Rezoning Transportation Analysis

Petition Number: #2022-047

General Location Identifier: 09513114

Date	Description
08-22-2022	First Review (AO)
09-21-2022	Second Review (AO)

REV.	A	Alezu Inc. GC License No. 78741
REV.	A 9/11/22	
REV.		Joseph Leland
REV.		Rezoning Site Plan
REV.		2718 Eastway Dr.
REV.		RZP 2022-047

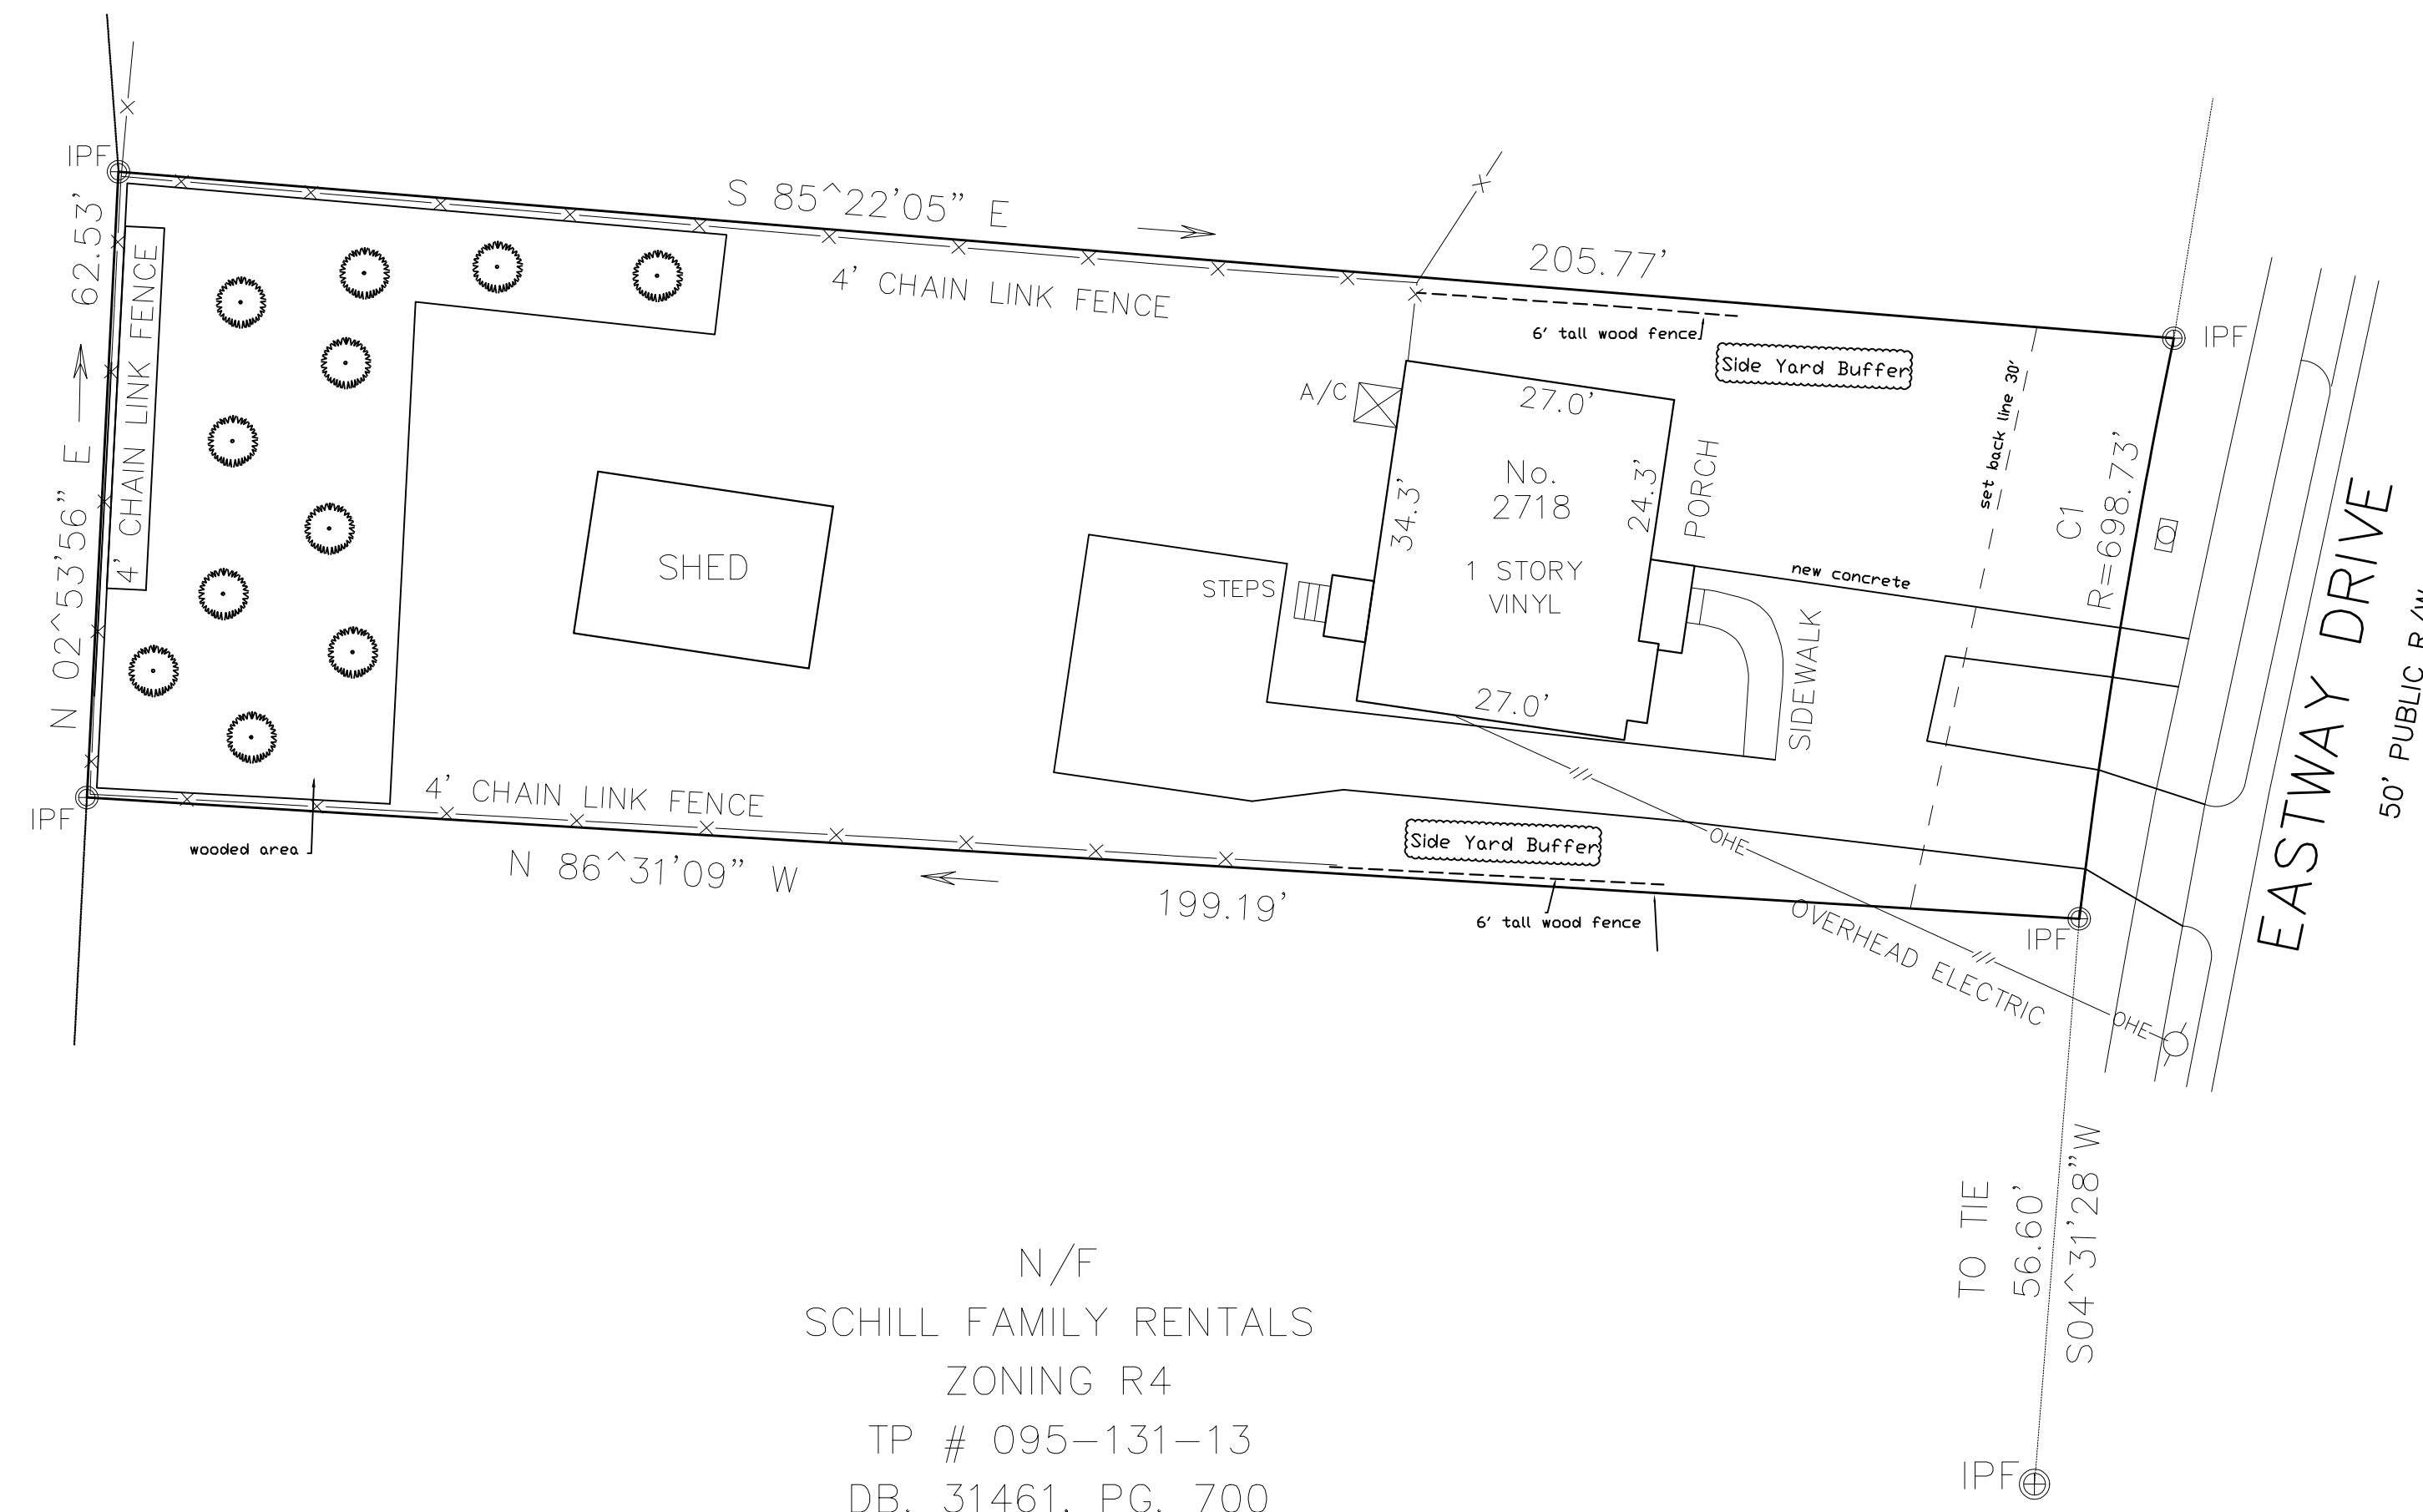
2. **Outstanding Comment from 8-22-22:** Revise site plan and conditional note(s) to commit to dedicate 40-feet of right-of-way from the road centerline of Eastway Dr. The site plan shall label and dimension the right-of-way from the road centerline.
